RR359 Emma Glass

**Street Works, Rights of Way and Access Plan
(Key Plan - Sheet 0 of 14)**

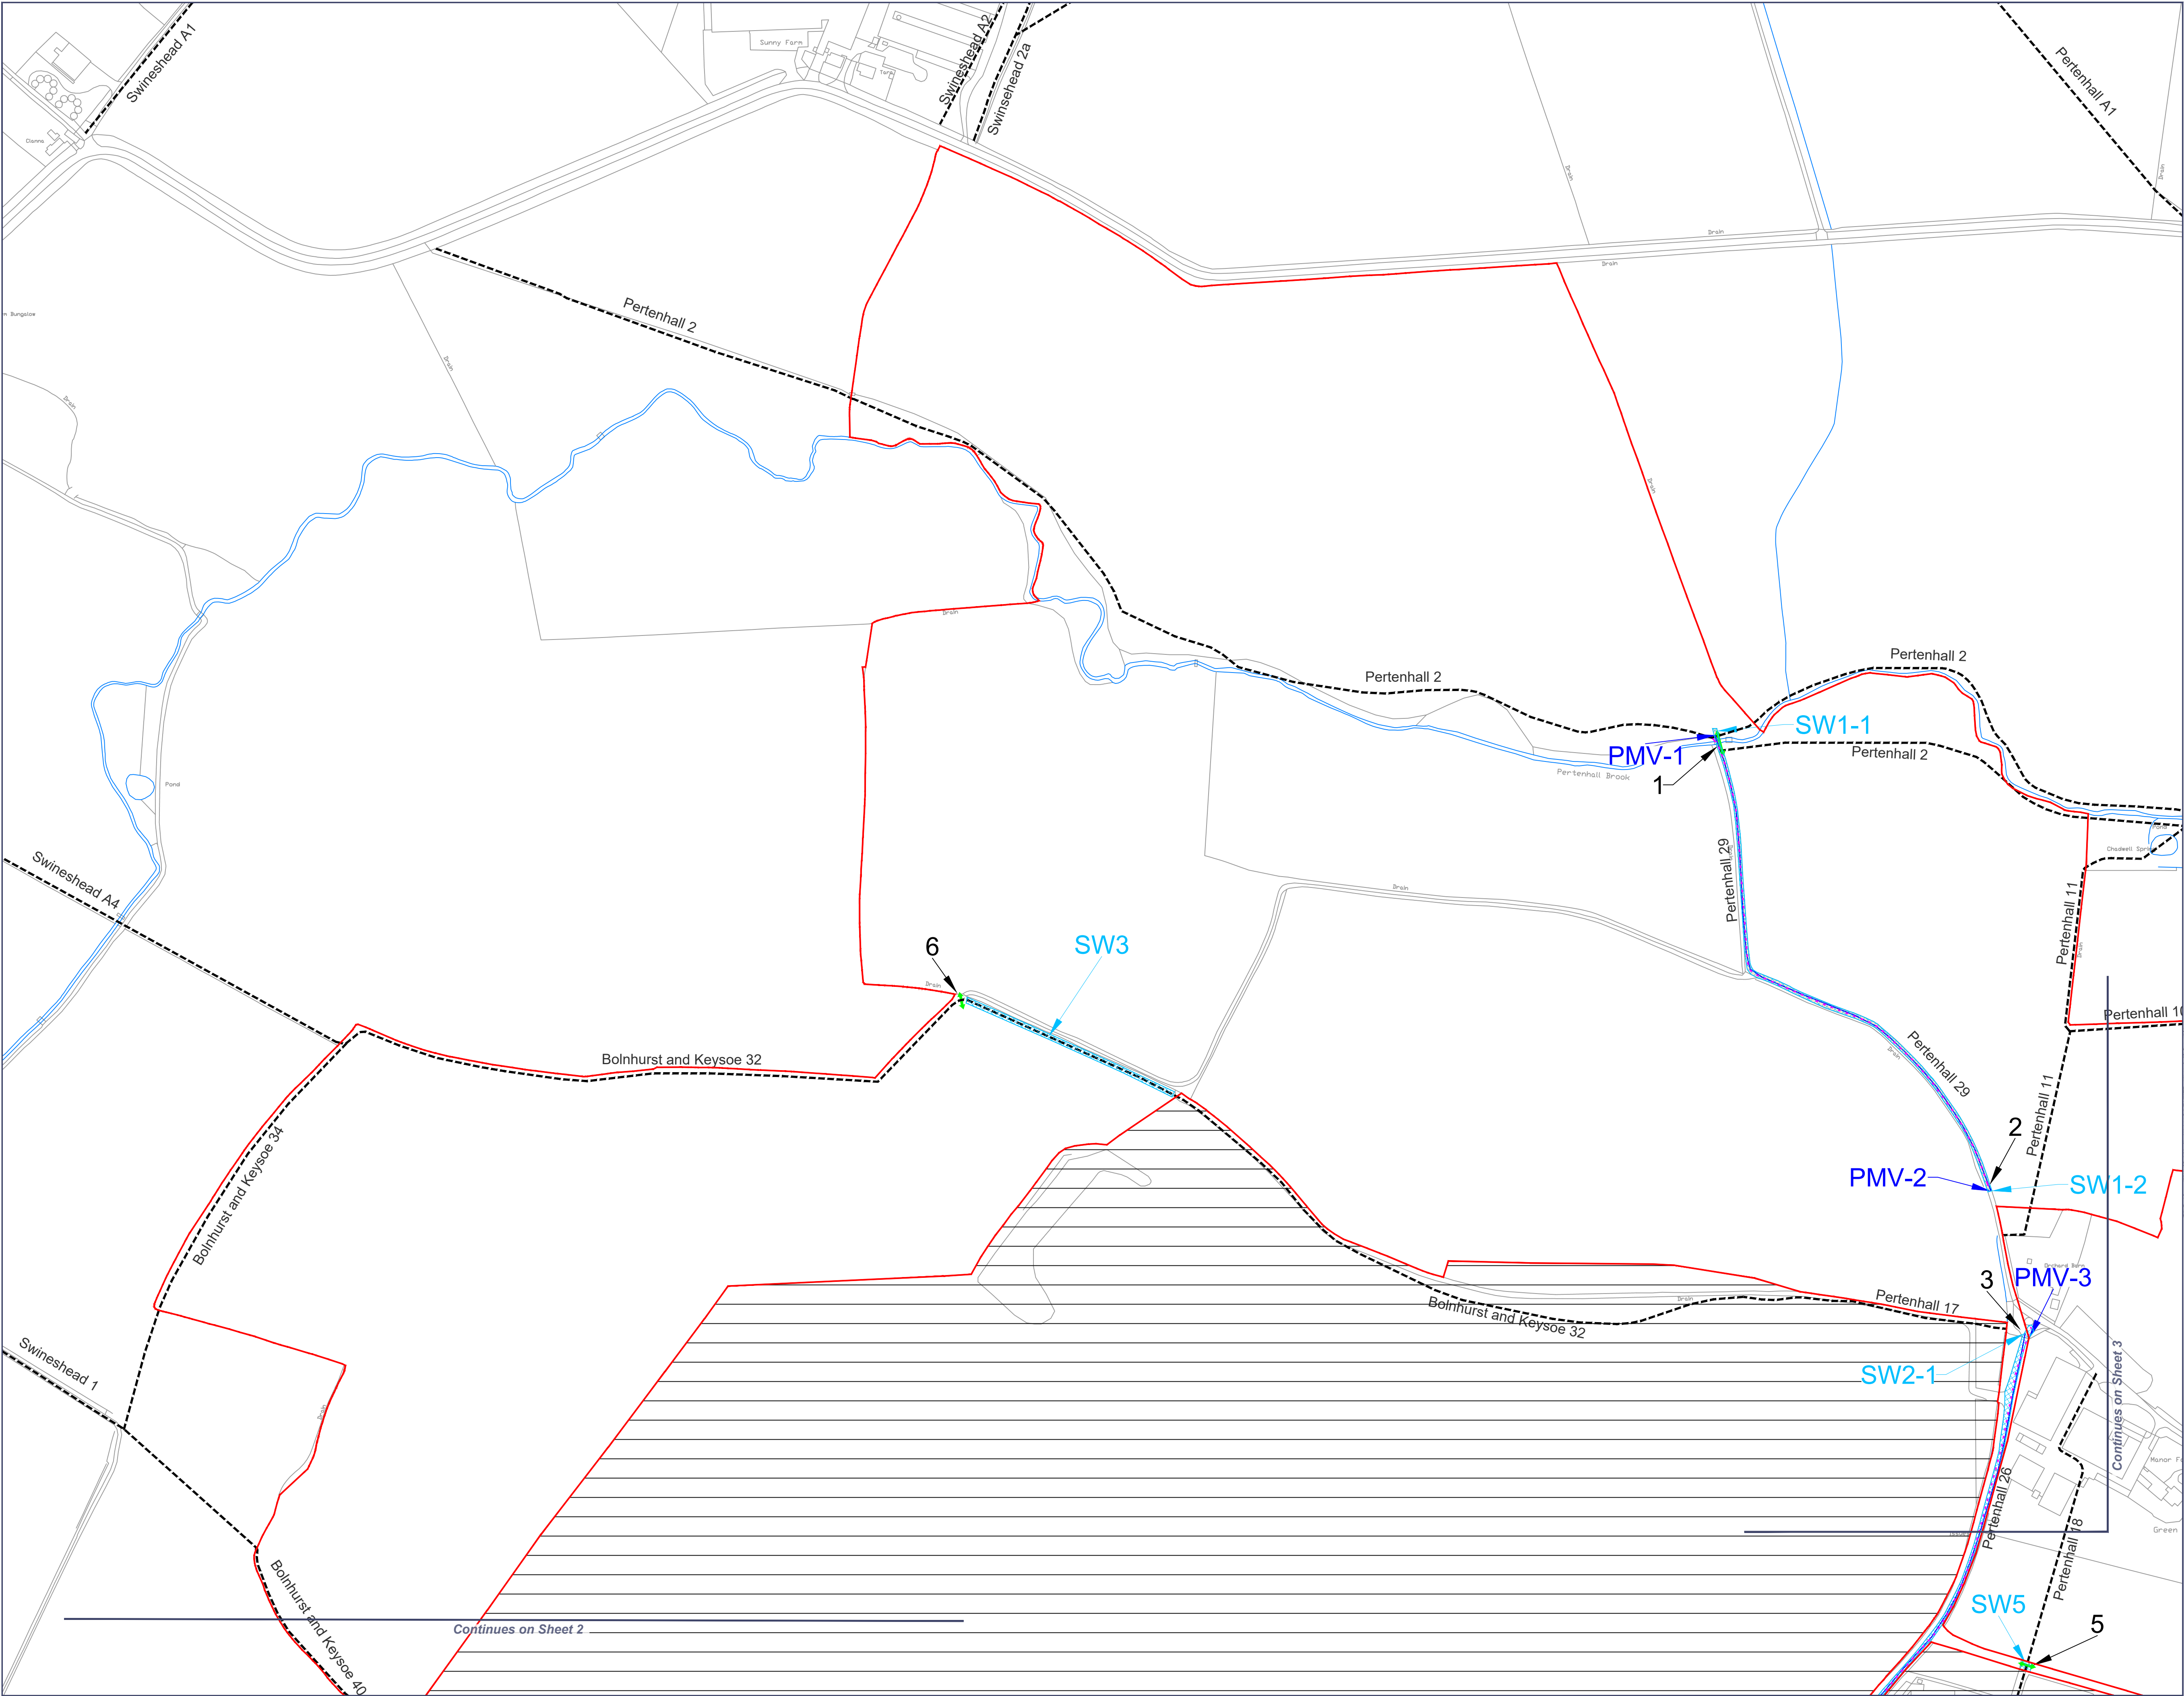
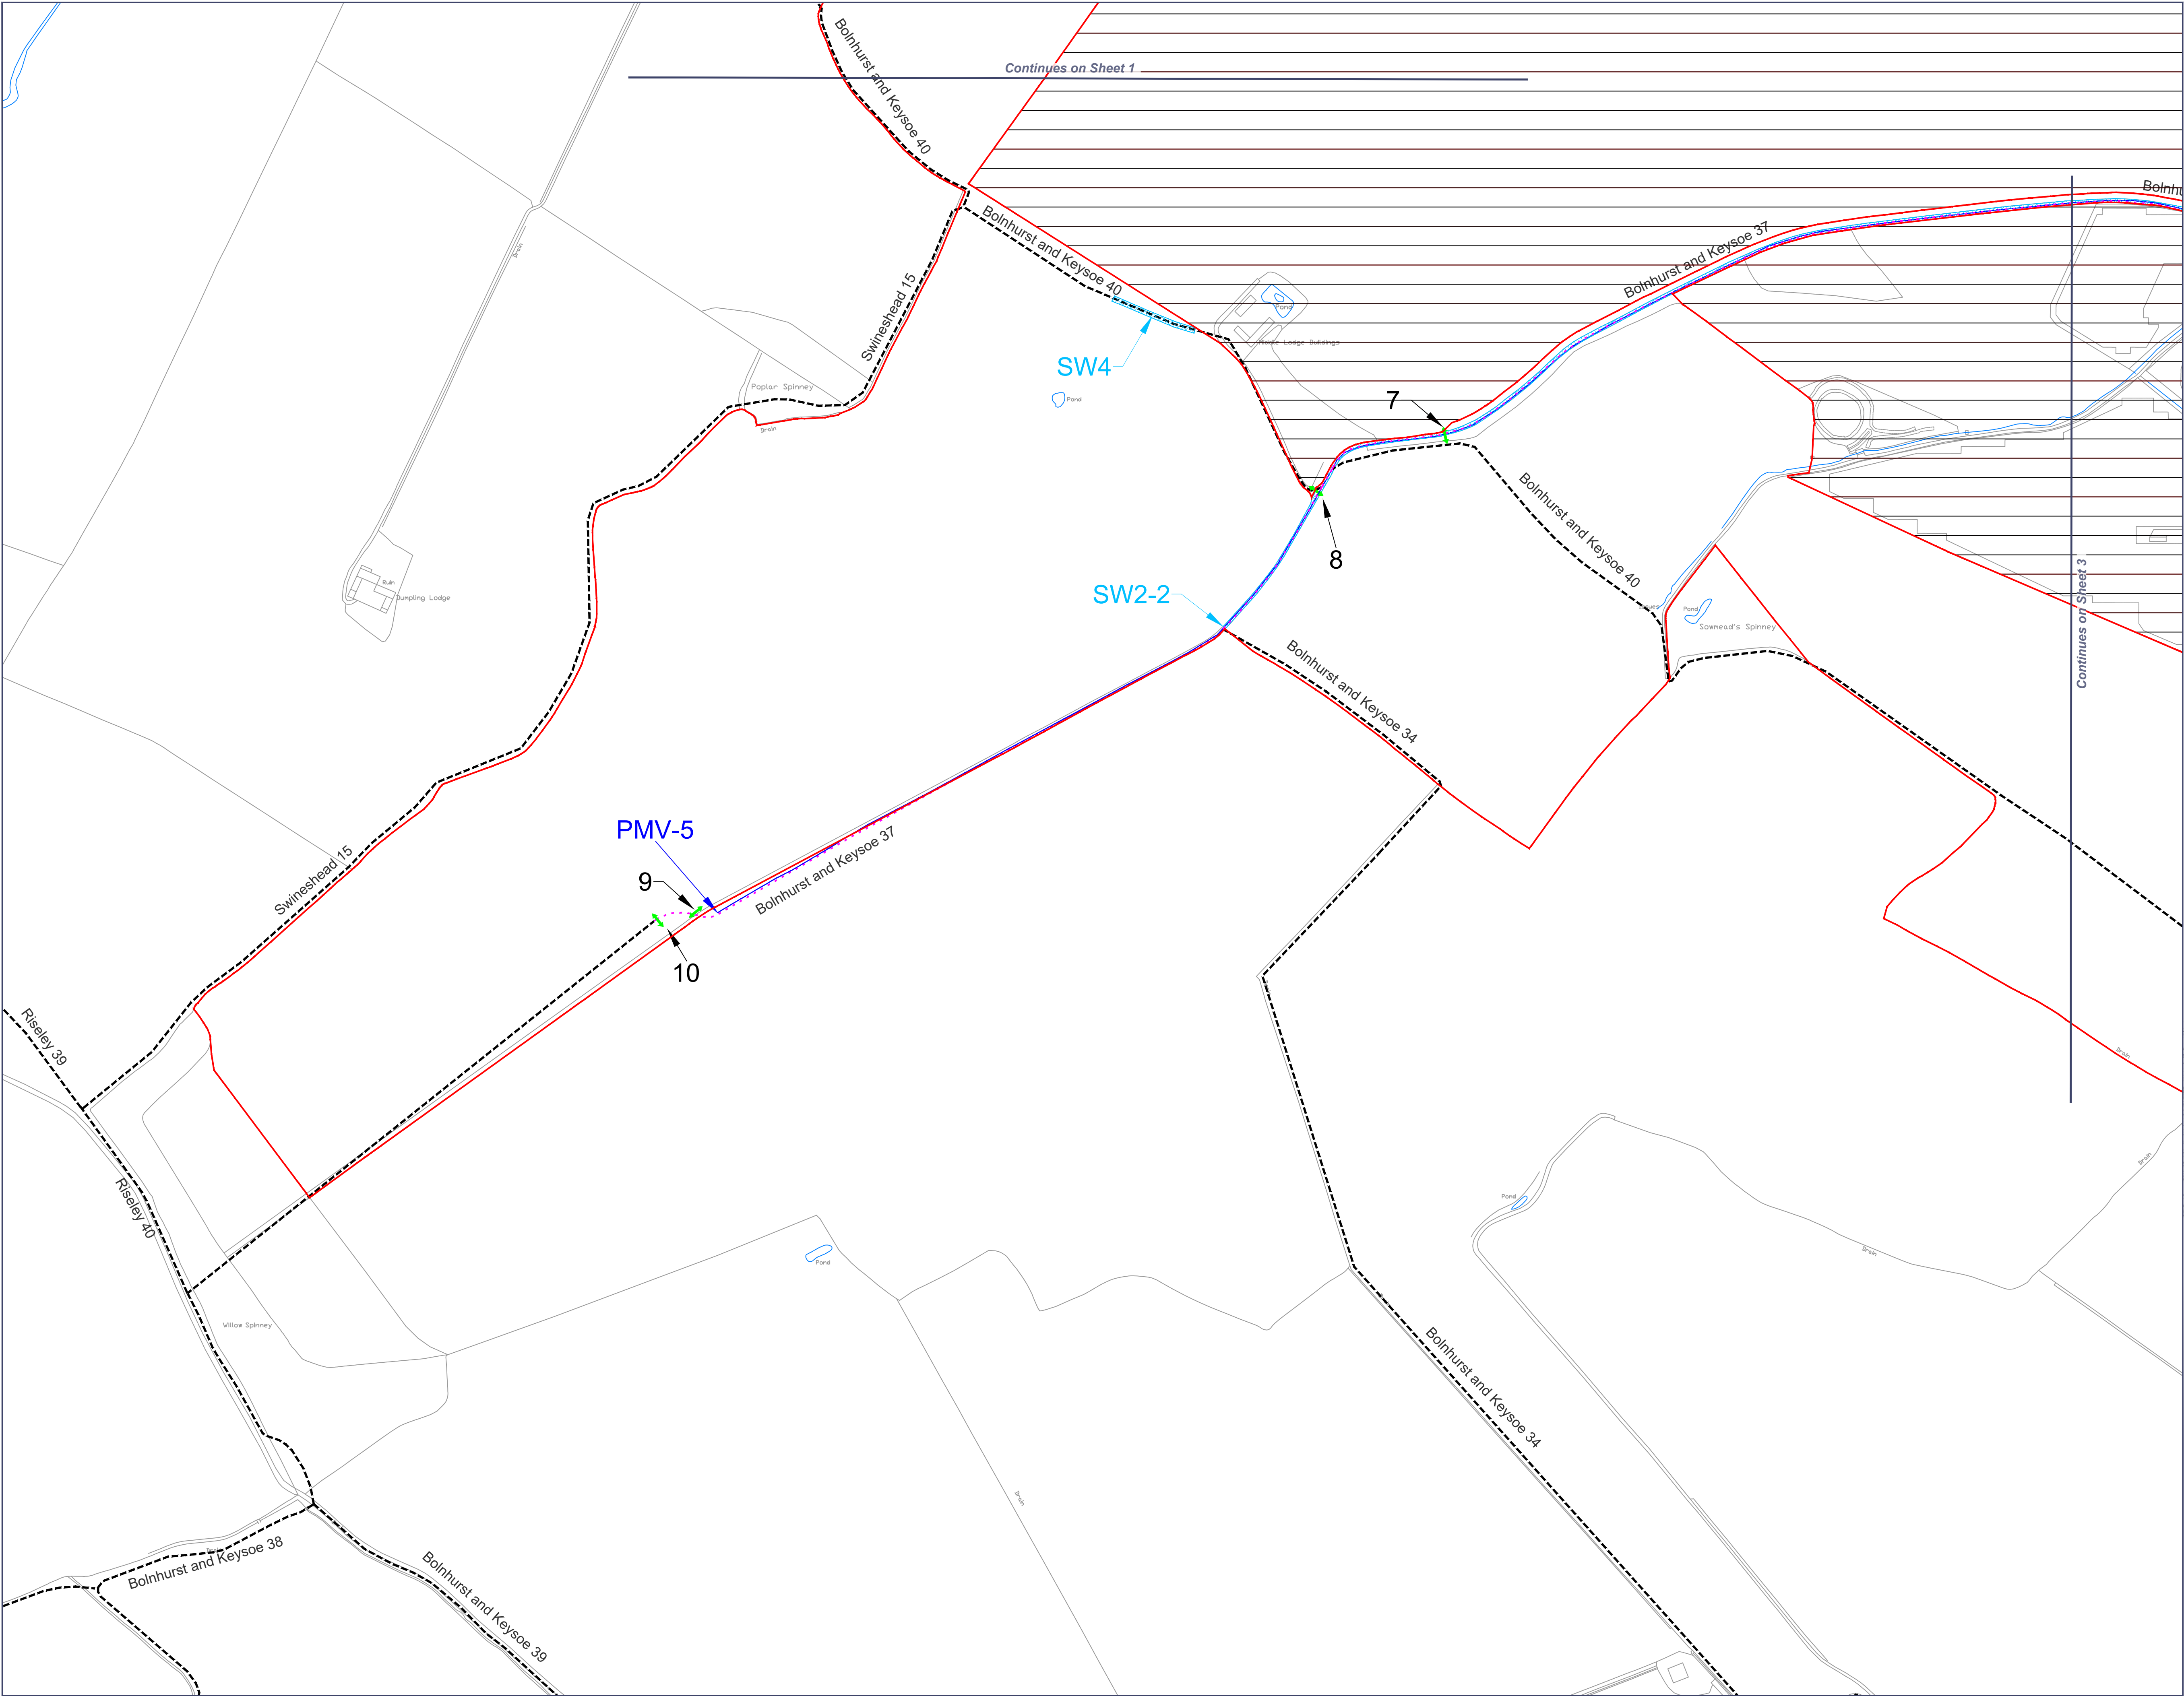
Finally, there is the issue of public rights of way. The suggestion that footpaths and bridleways will remain safely accessible during a 30-month construction period is unrealistic.

How will the safety of walkers, cyclists, and horse riders be guaranteed in practice?
